CITY OF ALBUQUERQUE

Re: The Bosque Center, Grading and Drainage Plan
Engineer's Stamp Dated 11-23-11 (D13/D009)

Based upon the information provided in your submittal dated 11-23-11, the above referenced plan is approved for Site Plan for Building Permit action by the DRB.

C-100

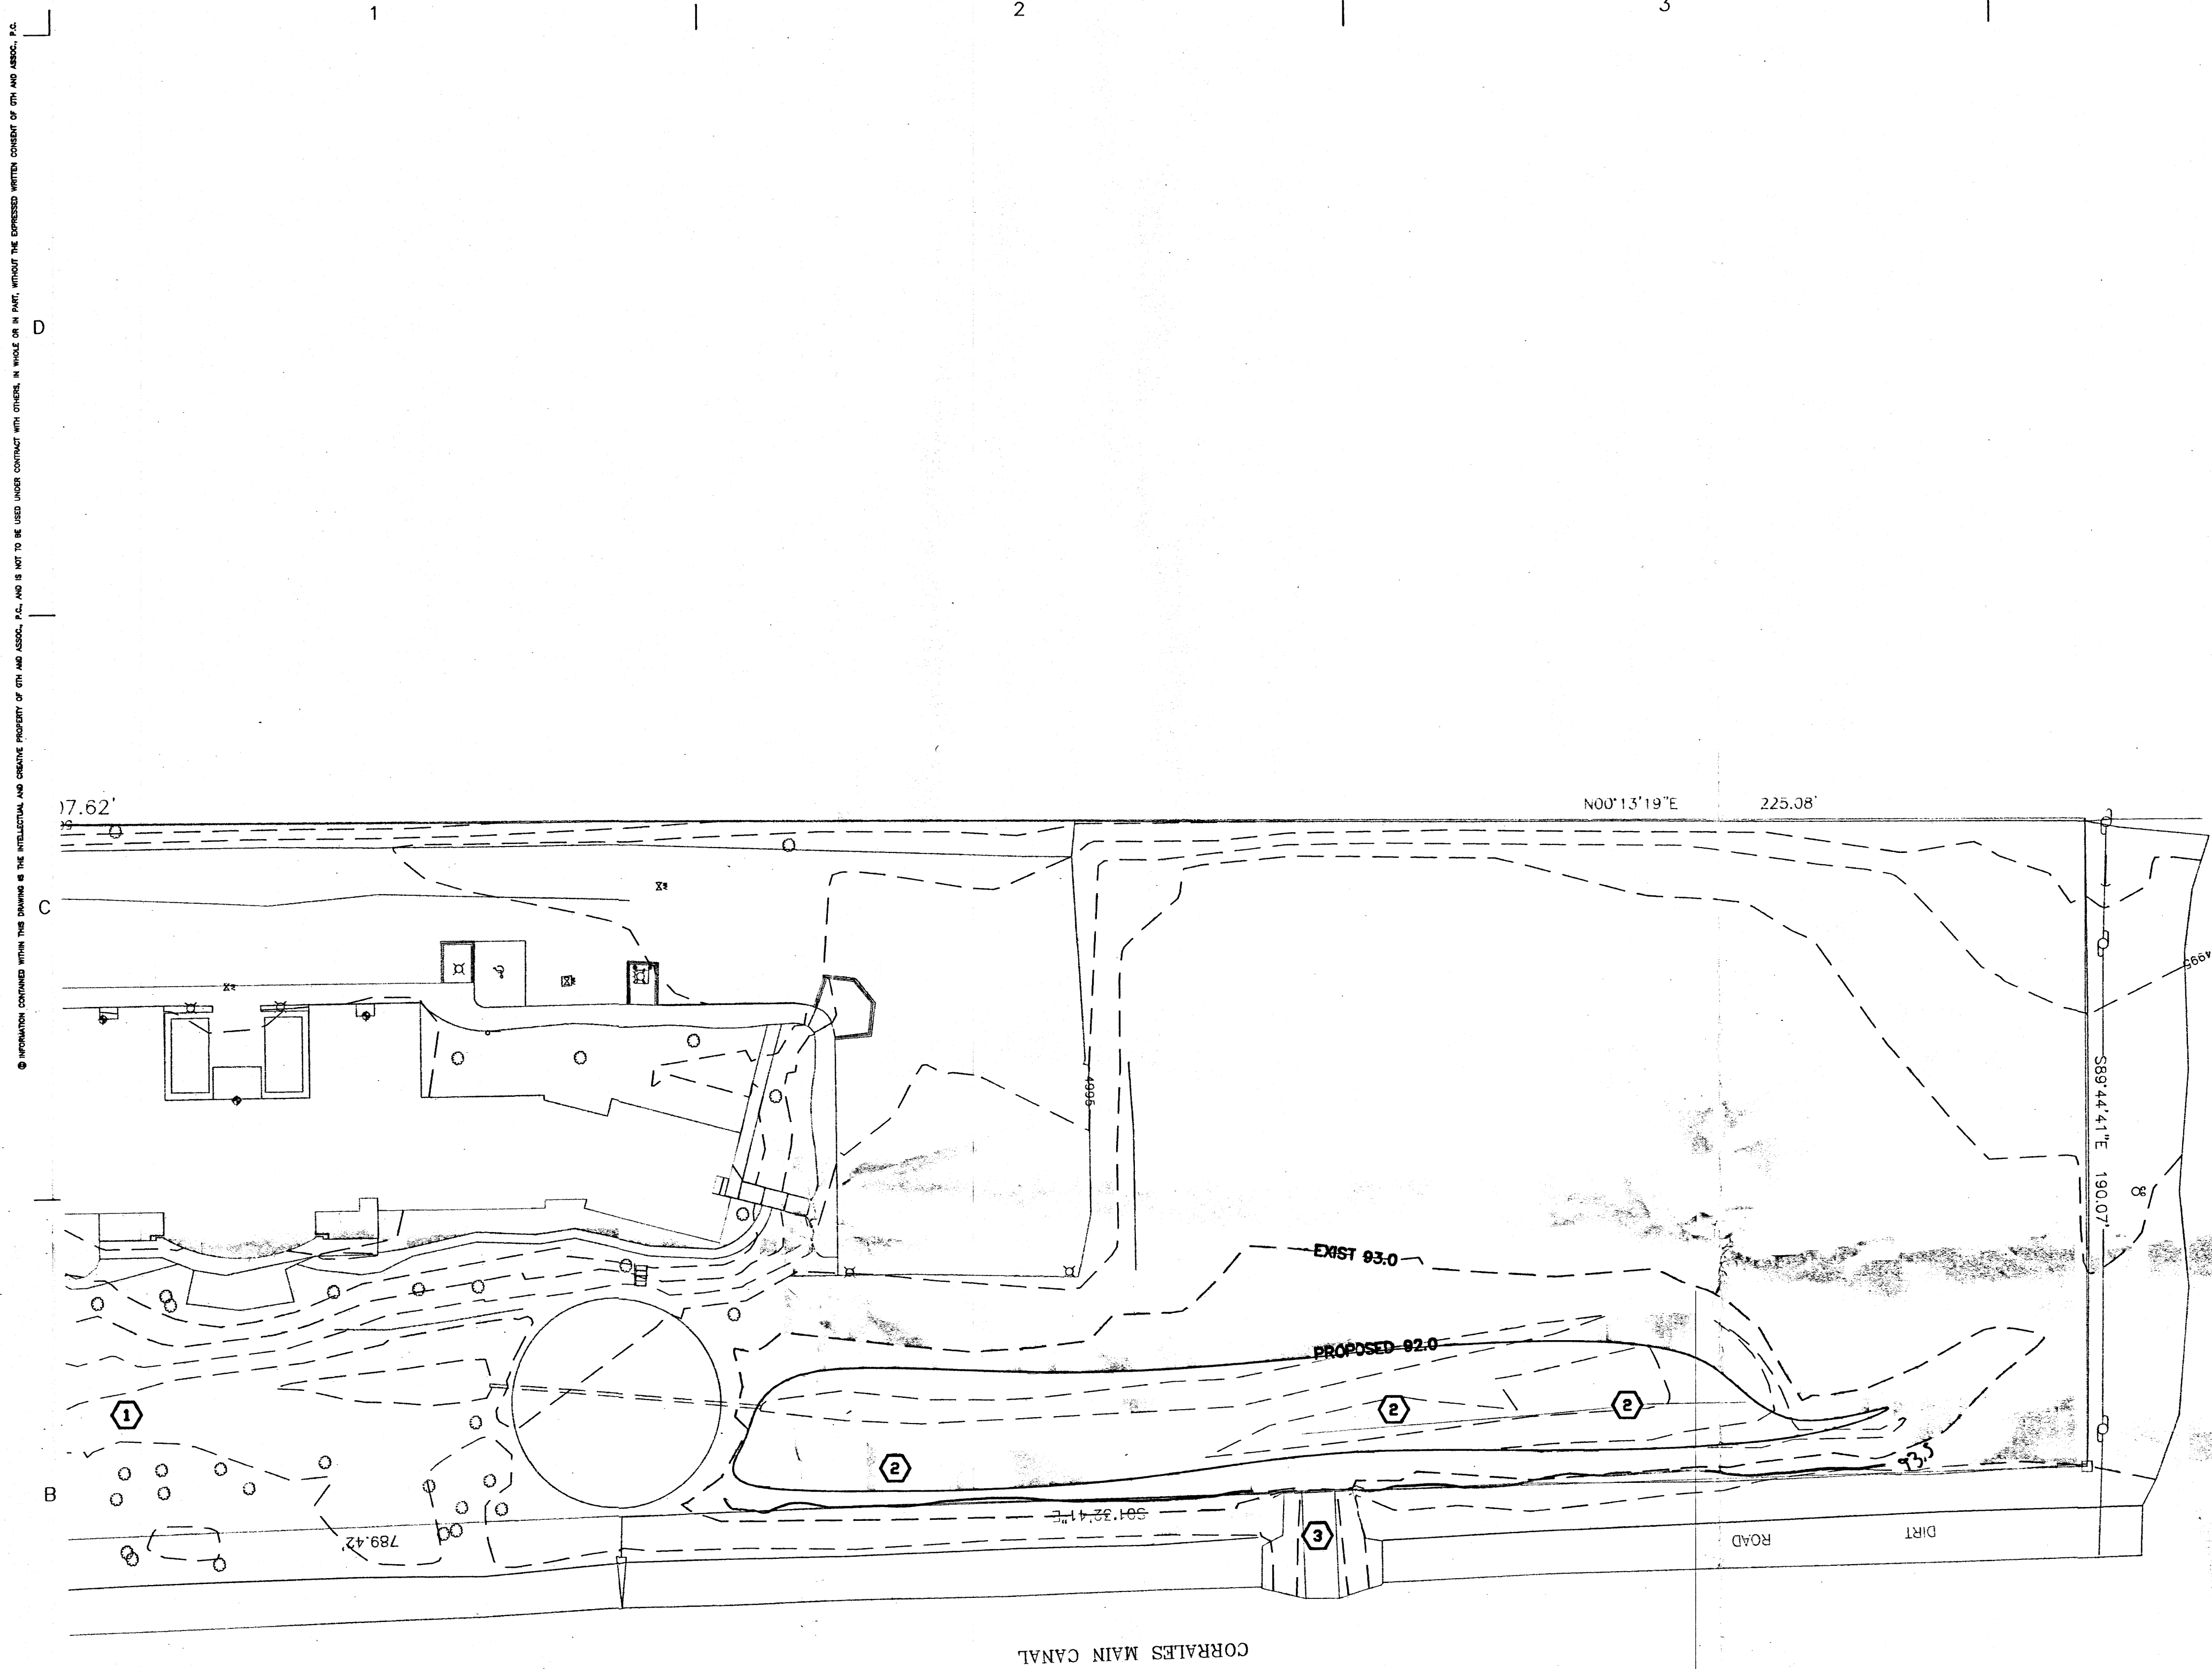
- AMAFCA approval is required. ✓
- The plan appears to meet the sedimentation goals of the North Coors DMP; however, it should be stated. ✓
- Provide the Volume Required, Volume Provided and WSE for each Water Harvesting Area on the Grading Plan. These values are part of the Certification.
- I couldn't find the Pond 2 routing in the AHYMO output. Please direct or provide.
- Please provide the AHYMO Summary Table.
- The Q Max numbers in the AHYMO output do not match the numbers in the Hydrology table.
- ~~The Peak Discharge Rate from Water Harvesting Area 1 in the AHYMO is 1.19 CFS. The rating curve for these pipes shows 1.05 cfs at an elevation of 96.~~
- Seems a small berm is required on the east side of Water Harvesting Area 5 (not at spillway) to ensure the spillway is the low point.
